**re: Geotechnical Response to City Comments  
Proposed Industrial Redevelopment  
135 Cardevco Road – Carp - Ontario**

**date: June 6, 2023**

**file: PG6018-MEMO.01 Revision 1**

PLAN: STORMWATER DETENTION AREAS

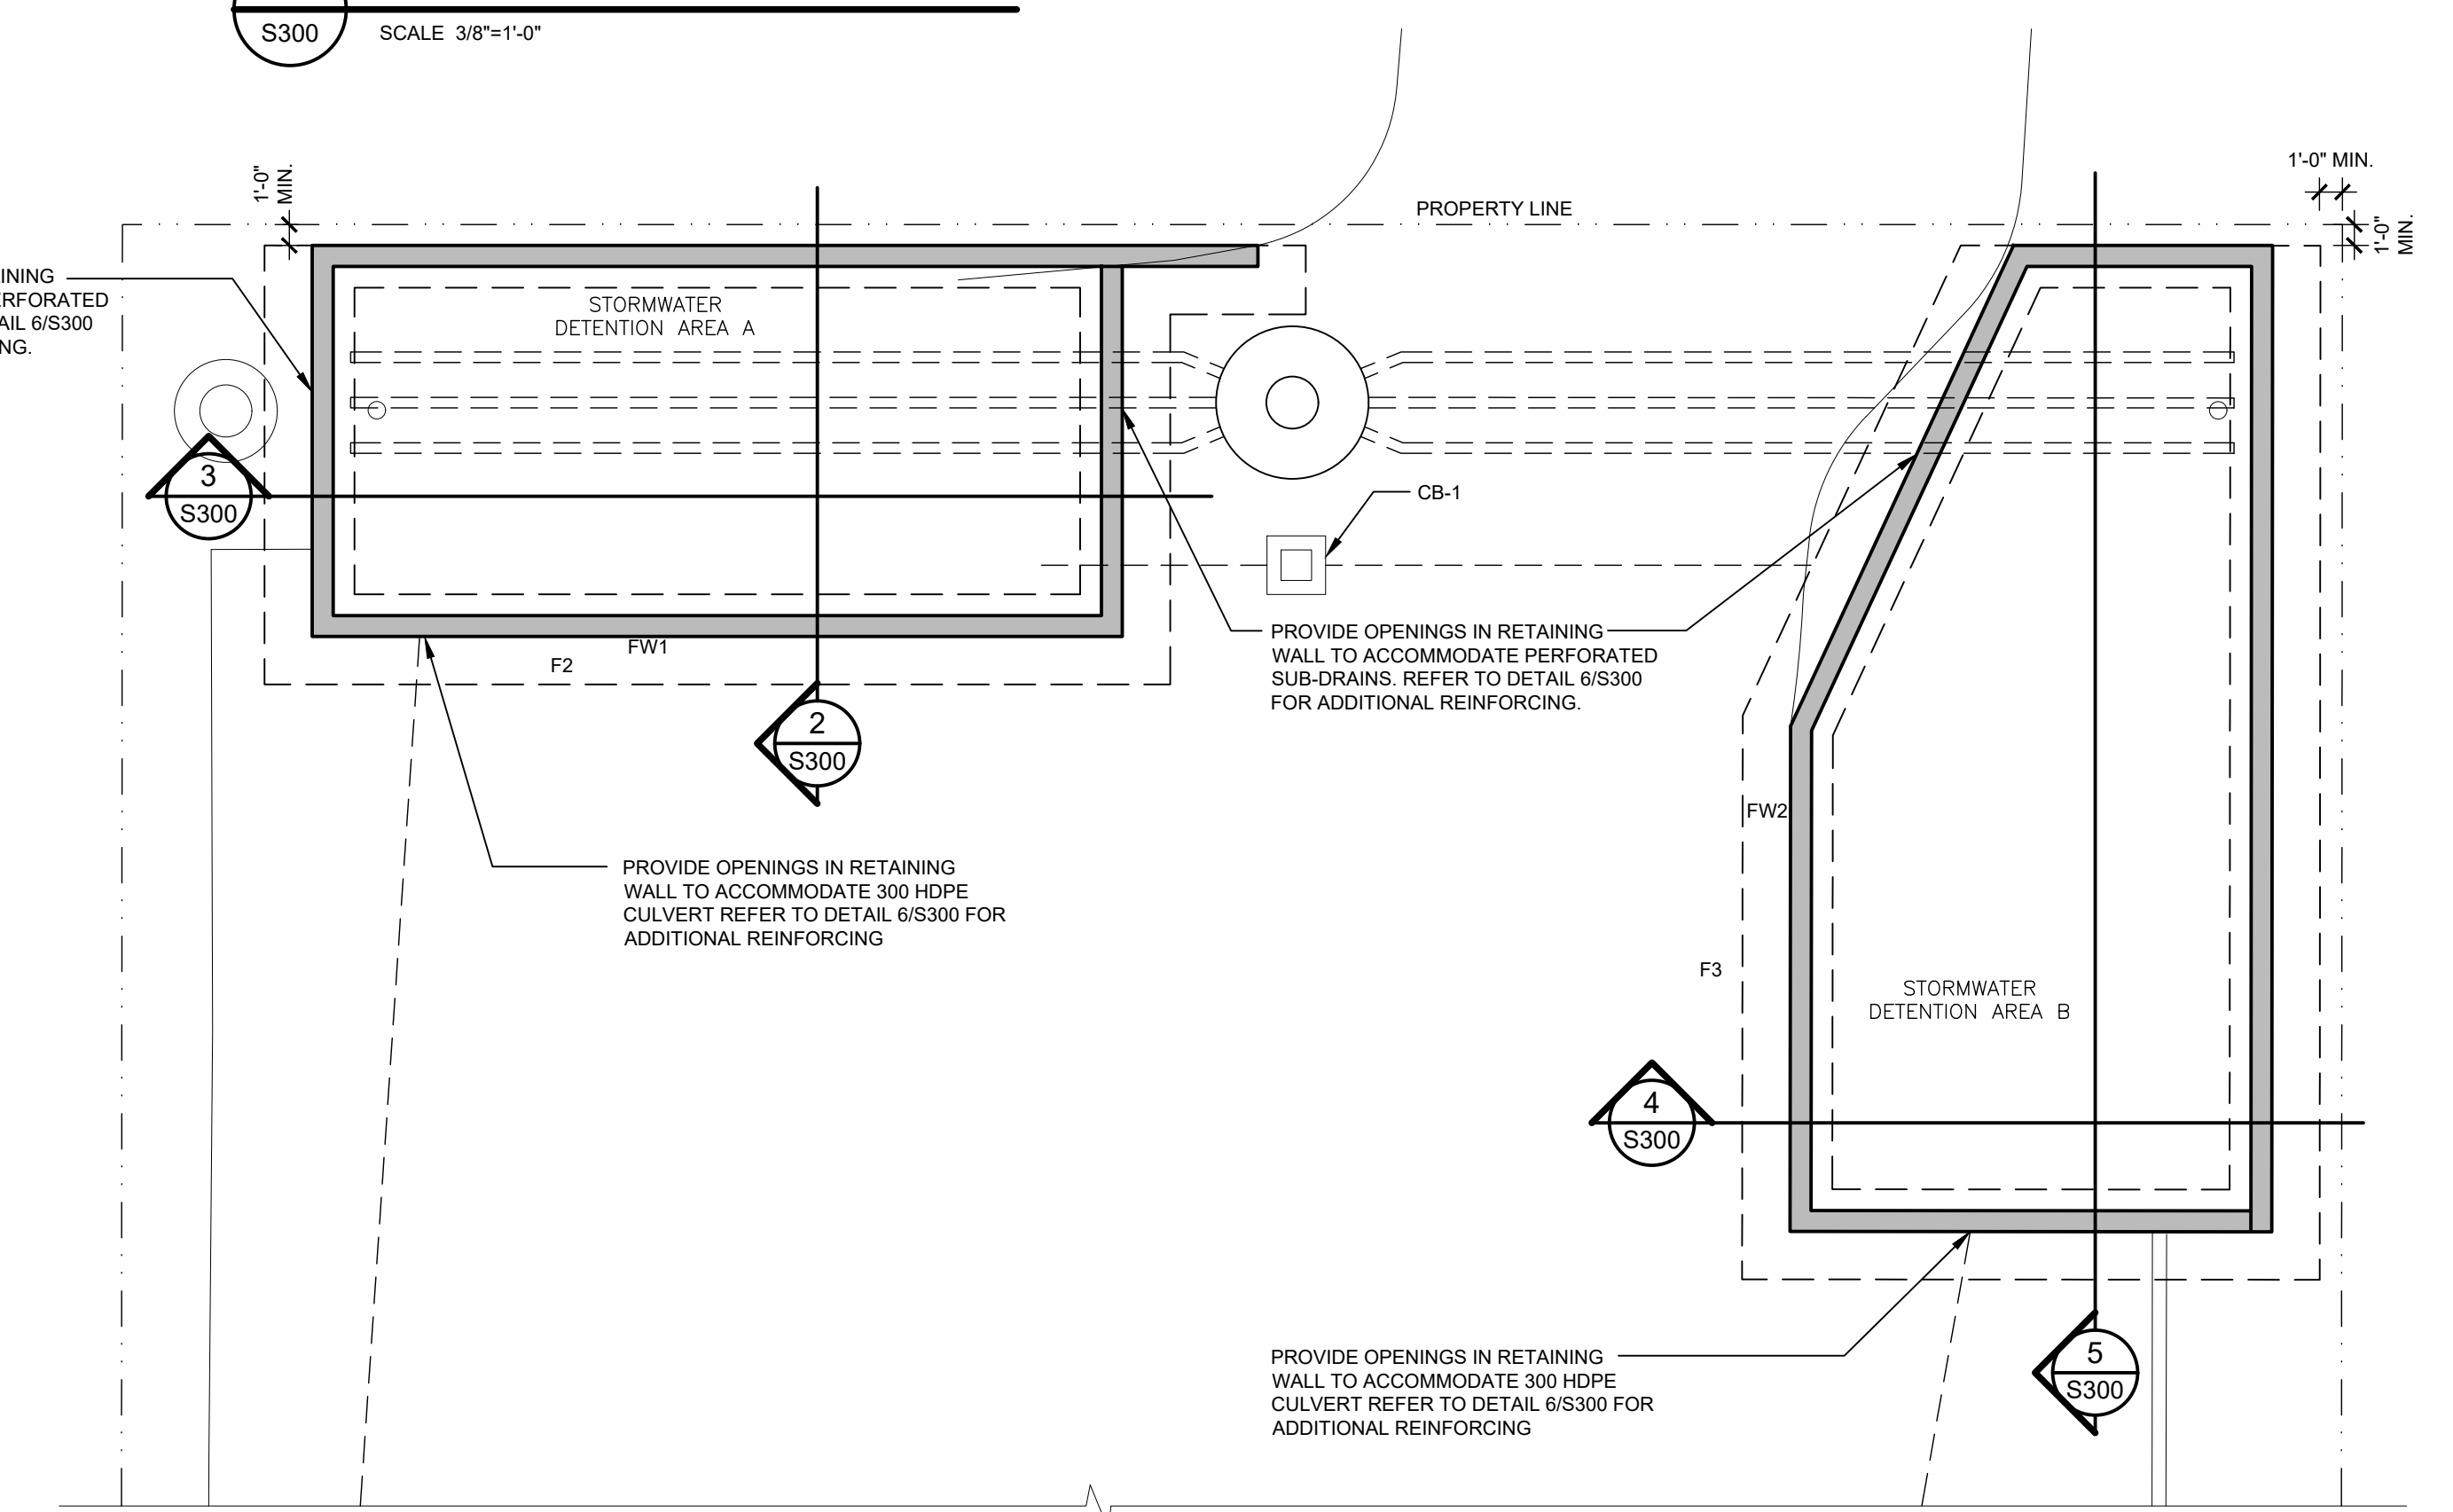
*There are proposed retaining walls on site, however no retaining walls/geotechnical considerations are provided in the report; please also investigate if slope stability considerations apply.*

It is understood that the design of retaining walls will be done by others and is outside the scope of the geotechnical report. However, Paterson can provide a design for retaining walls if requested. For slope stability analysis, the ground surface at the subject site is generally flat and slopes gently from approximate geodetic elevation 119.3 to 118.5 at the west and east sides, respectively. In addition, there is no watercourse noted within the proximity of the subject site. Therefore, no slope stability analysis is required for the subject development.
